help re planning for refurbishment in listed building please

I shall shortly be purchasing 16 Bond Street, Arundel (BN18 9BL) when probate has been granted [REDACTED] (the former owner). Very little has been done to the house since it was bought for [REDACTED] the mid 1960s and I intend refurbishing it to modernize the facilities whilst retaining the cottage's unique character – i.e.

Refrubishment of
16 Bond St
ARUNDEL, West Sussex.
Existing + Proposed Outhouse.
Scale 1:50 @ A3.

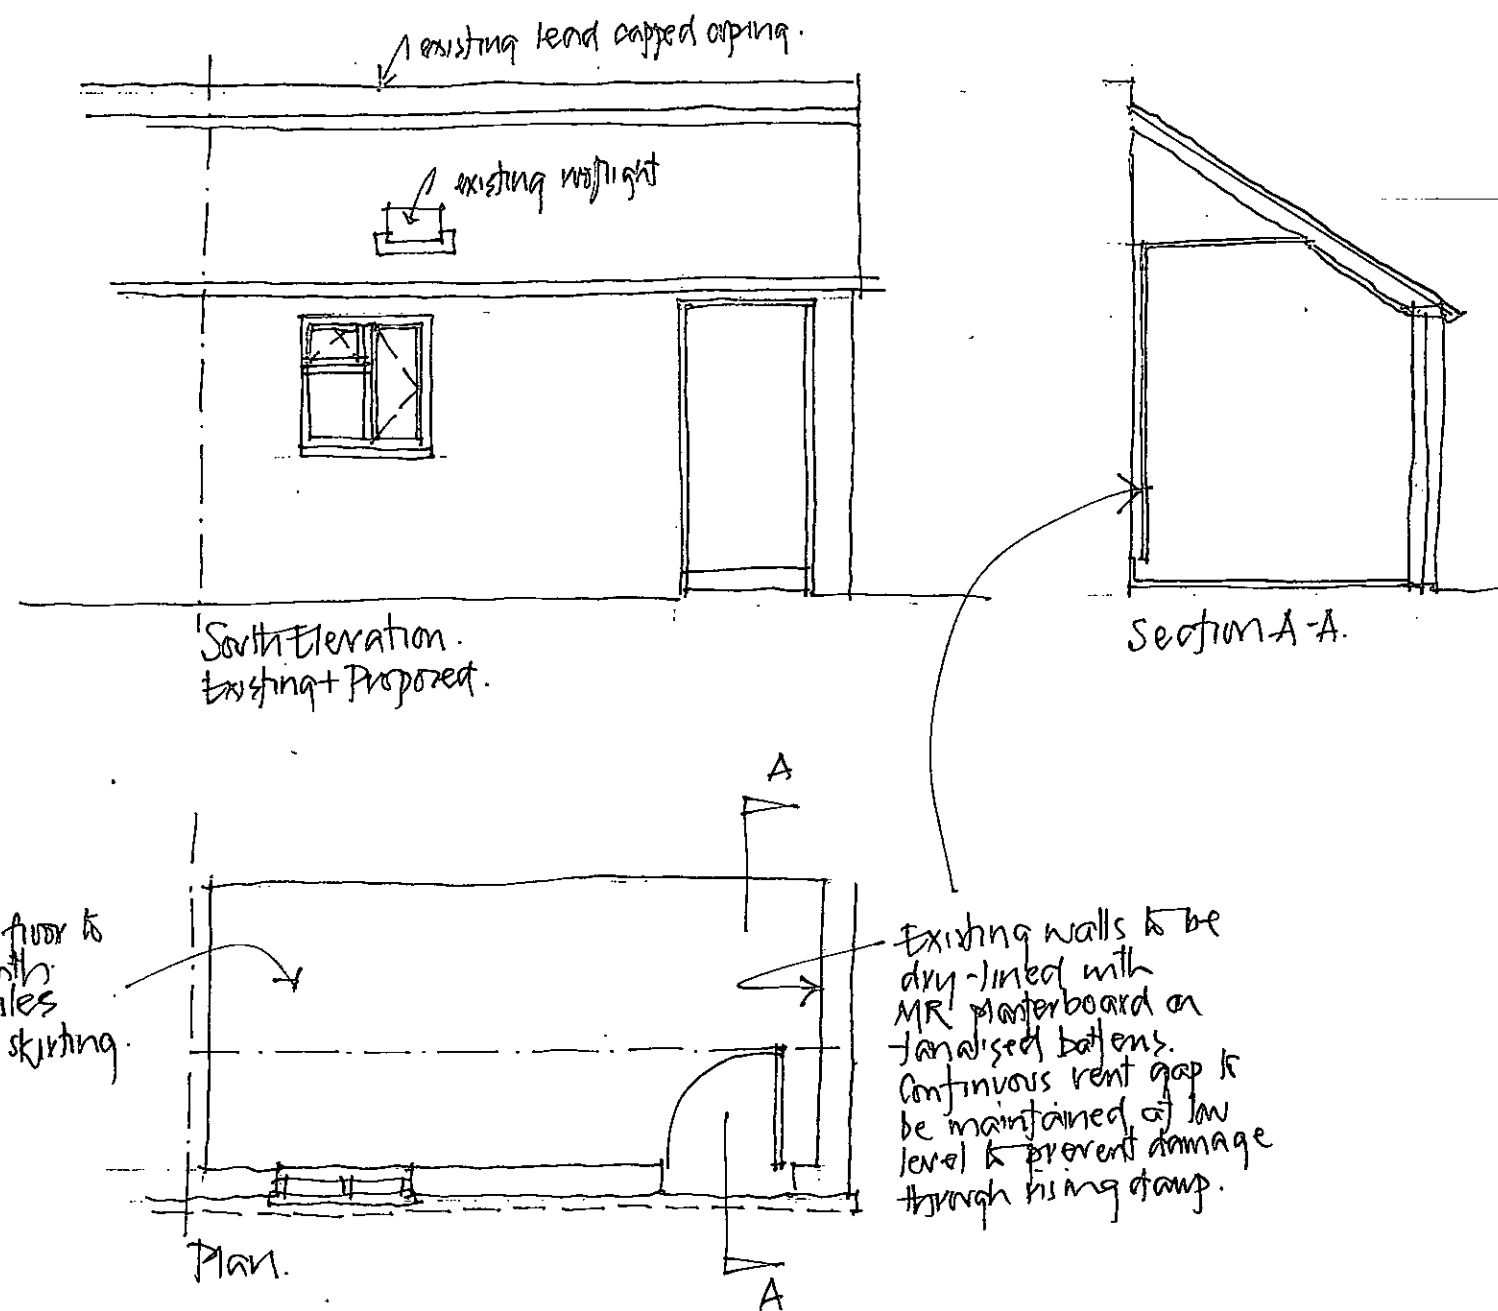
- replace the windows to match the rest of the street - this will require listed building consent – please note that as the property is listed, they will need to be single glazed.
- make an access into the roof space to add insulation - this will require listed building consent
- dealing with the damp in the outhouse and refurbishing it as a utility/storage room - this will require listed building consent

Refurbishment of
16 Bond St.
ARUNDEL West Sussex.
Floor Plans - Proposed
Scale 1:50 @ A3

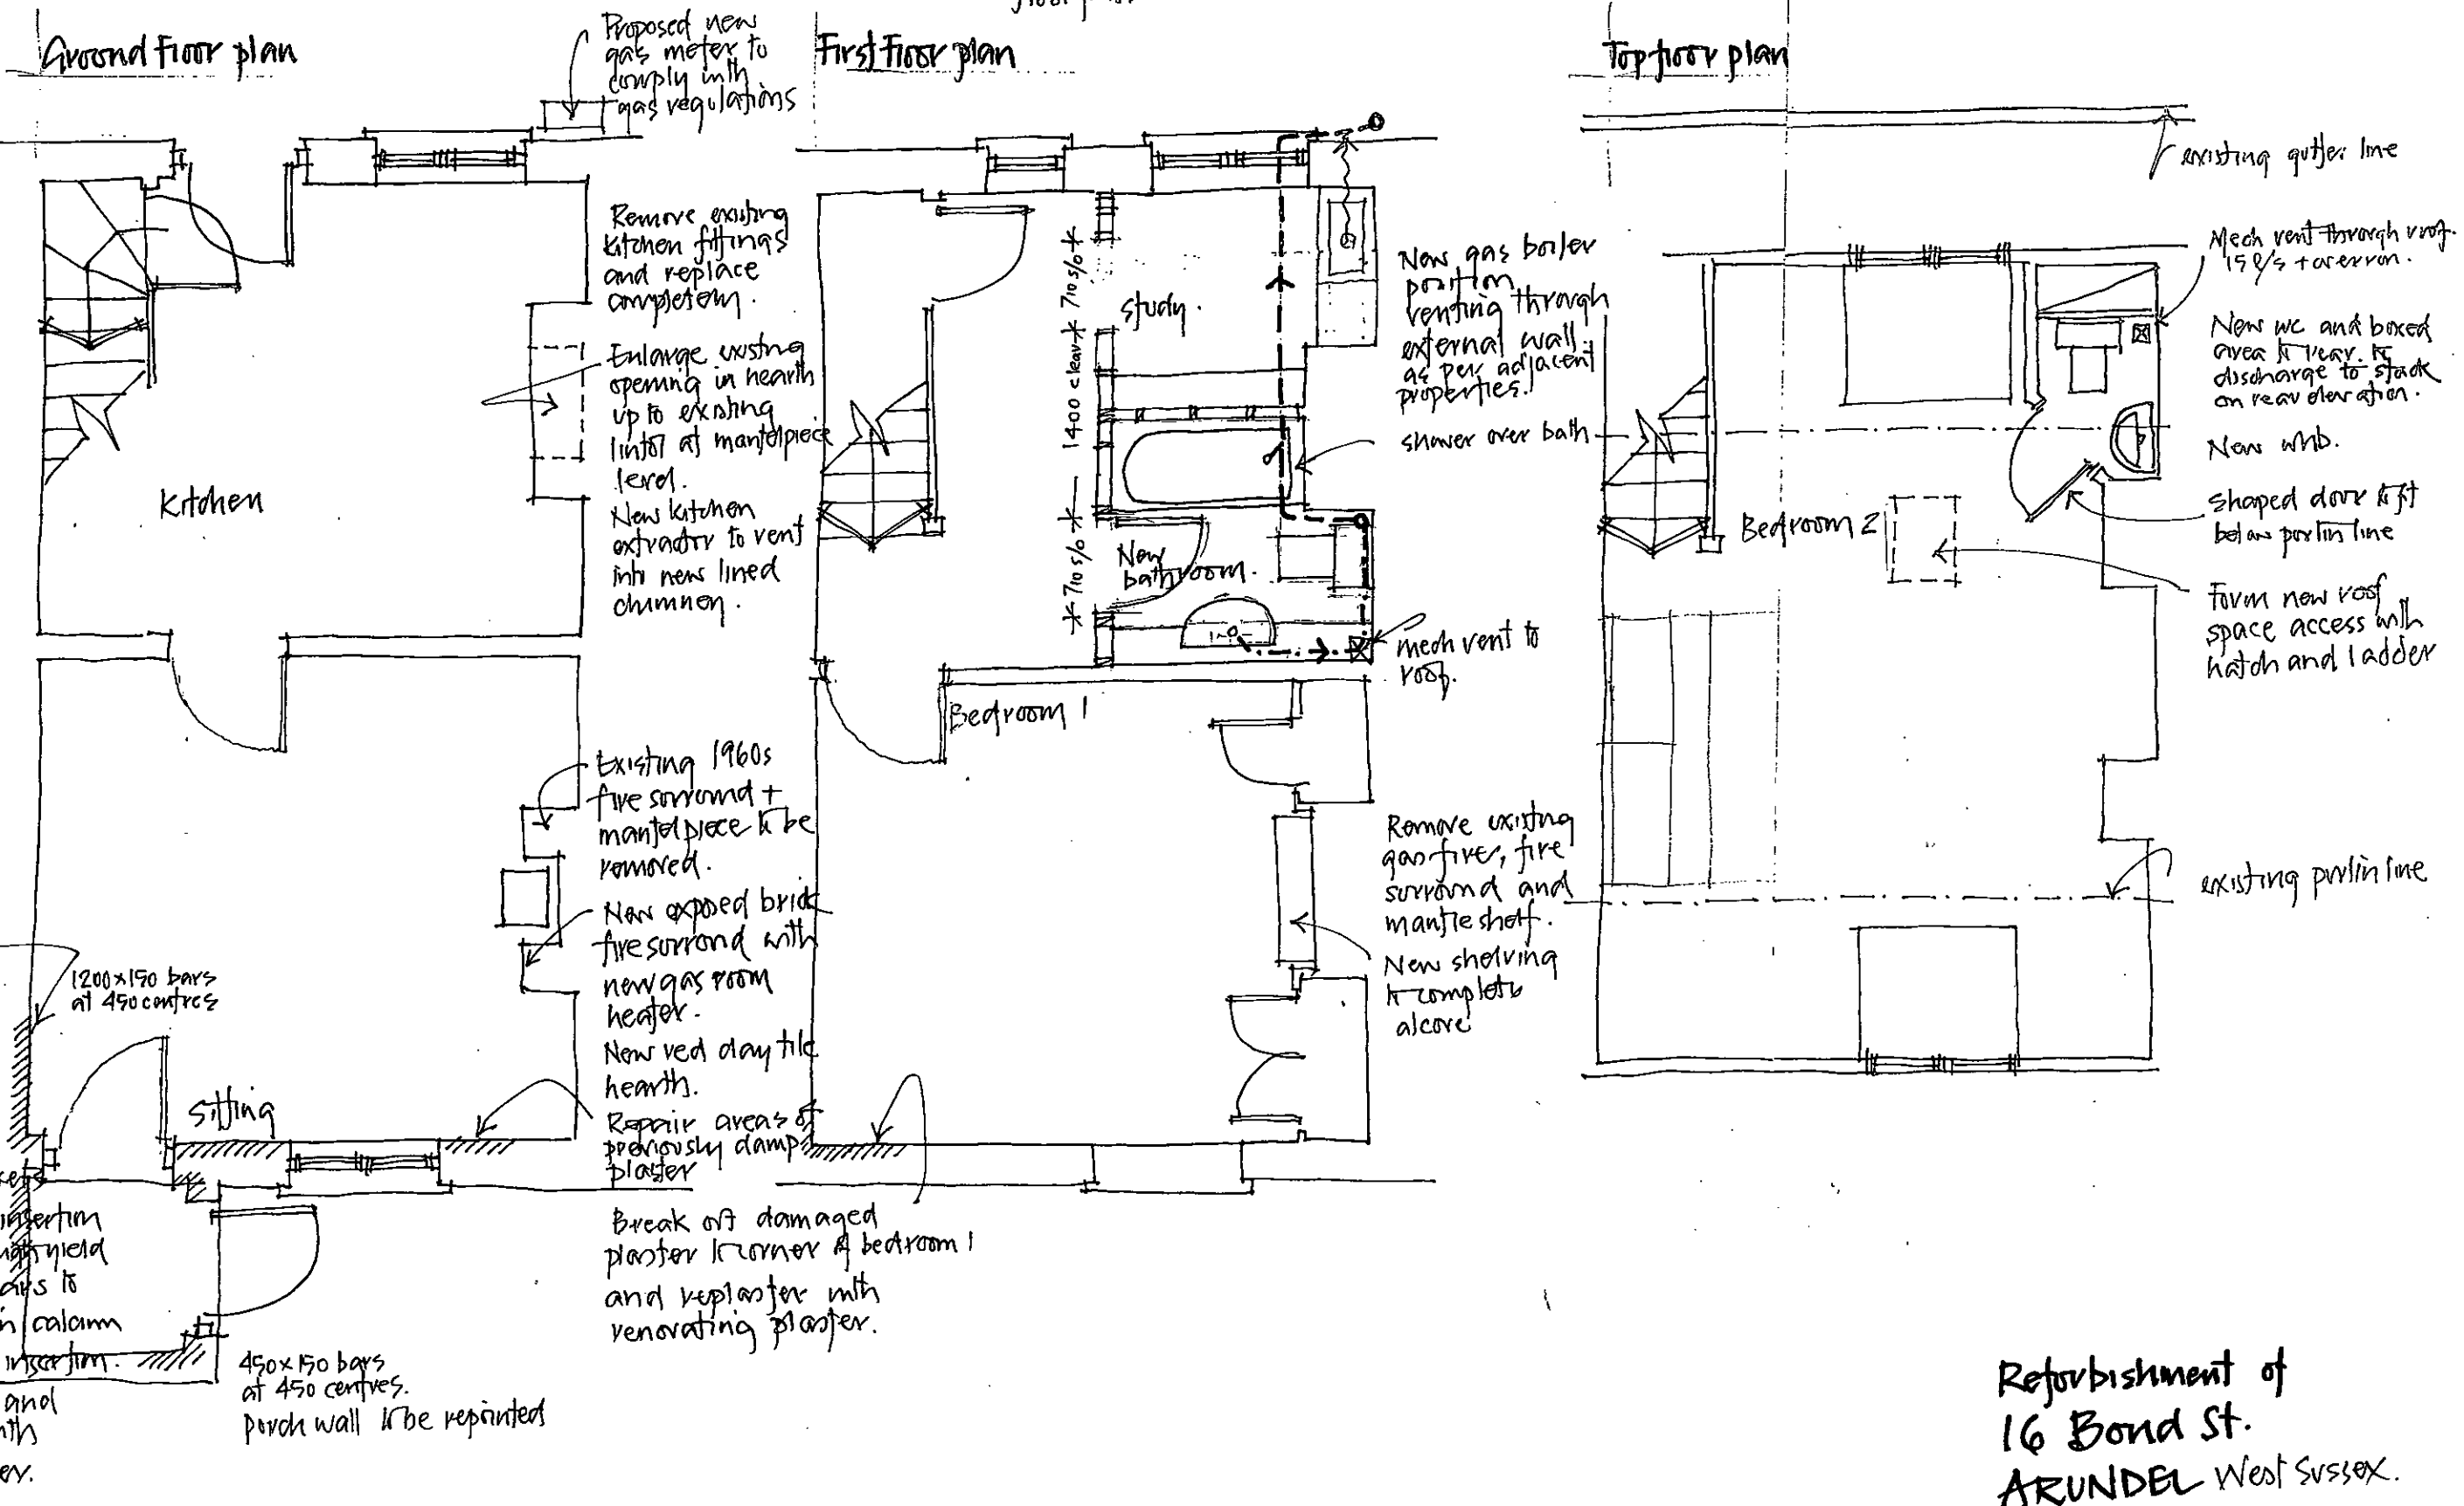
- replace the kitchen, re-opening in the chimney breast to accommodate a cooker – replacing the kitchen will not require consent if it is a 'modern' one. The works to the chimney breast may require listed building consent. Please can you provide me with more information about the type of works that you would undertake to the chimney breast

- replace the bathroom, adding a partition wall to create a study area (and an access opening in the existing partition wall (non structural)) – the addition of a partition wall and new opening will both require listed building consent

- add en suite facilities to the top bedroom – if facilities are not currently present this will require listed building consent
- replace the existing built-in wardrobes etc – if these are modern wardrobes which will not involve the removal of any internal walling etc, consent will not be required
